Howerton Services, PLLC
License # P-1716
3513 Cathedral Bell Road
Raleigh, NC 27614
(919) 270-3460

Subject: 414 Lambert Lane
Fuquay Varina, NC 27526
Framing Modification Letter
Harnett County Permit #: SFD2209-0016

S-4

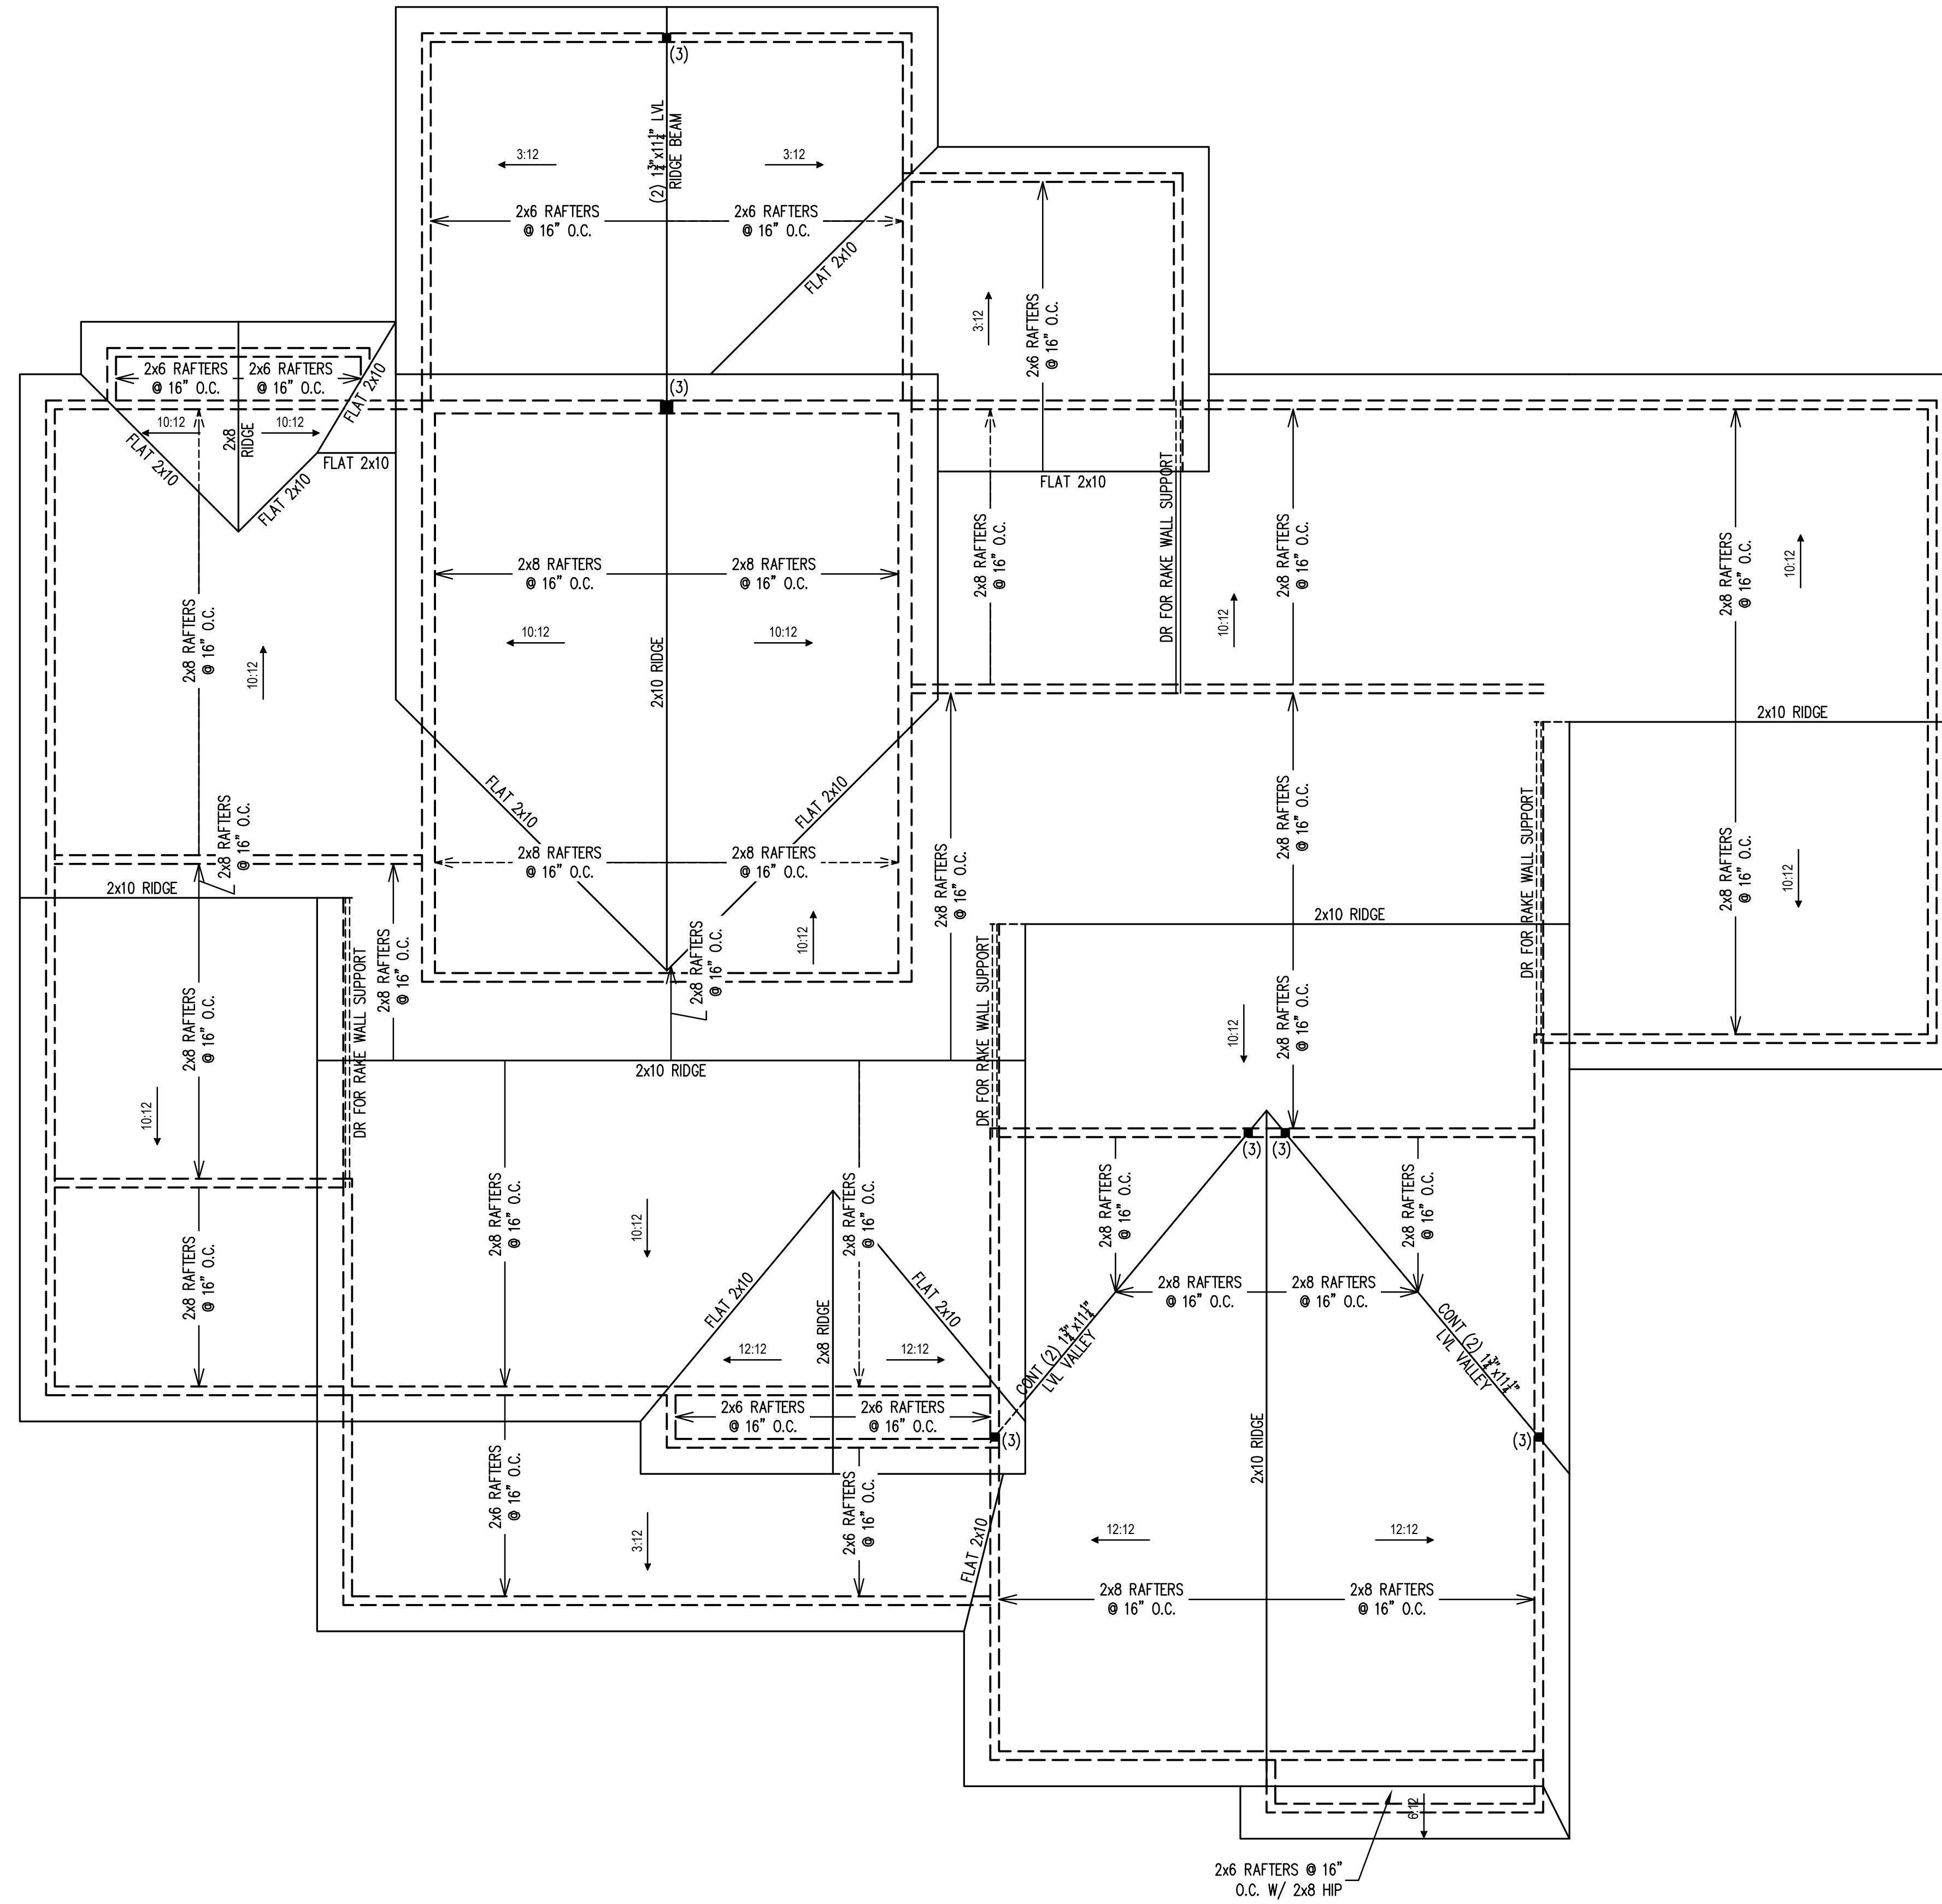
Based on the request of the Contractor, the support for the LVL ridge beam for the rear porch was modified. I also inspected a hole drilled into an LVL beam. My assessment and recommendations are as follows:

- In lieu of a triple stud column under the interior end of the LVL ridge beam, the Contractor connected the LVL ridge to the side of the stud column with a Simpson HGUS410 hanger. The hanger method for support and the type of hanger is acceptable.
- The electrician drilled a ½” vertical hole in a 1 member of a double 9 ¼” LVL beam. This hole is acceptable. No repair is required.

The hanger attachment for the LVL ridge beam and the modified double 9 ¼” LVL beam meet all the requirements of the 2018 North Carolina Building Code for Residences.
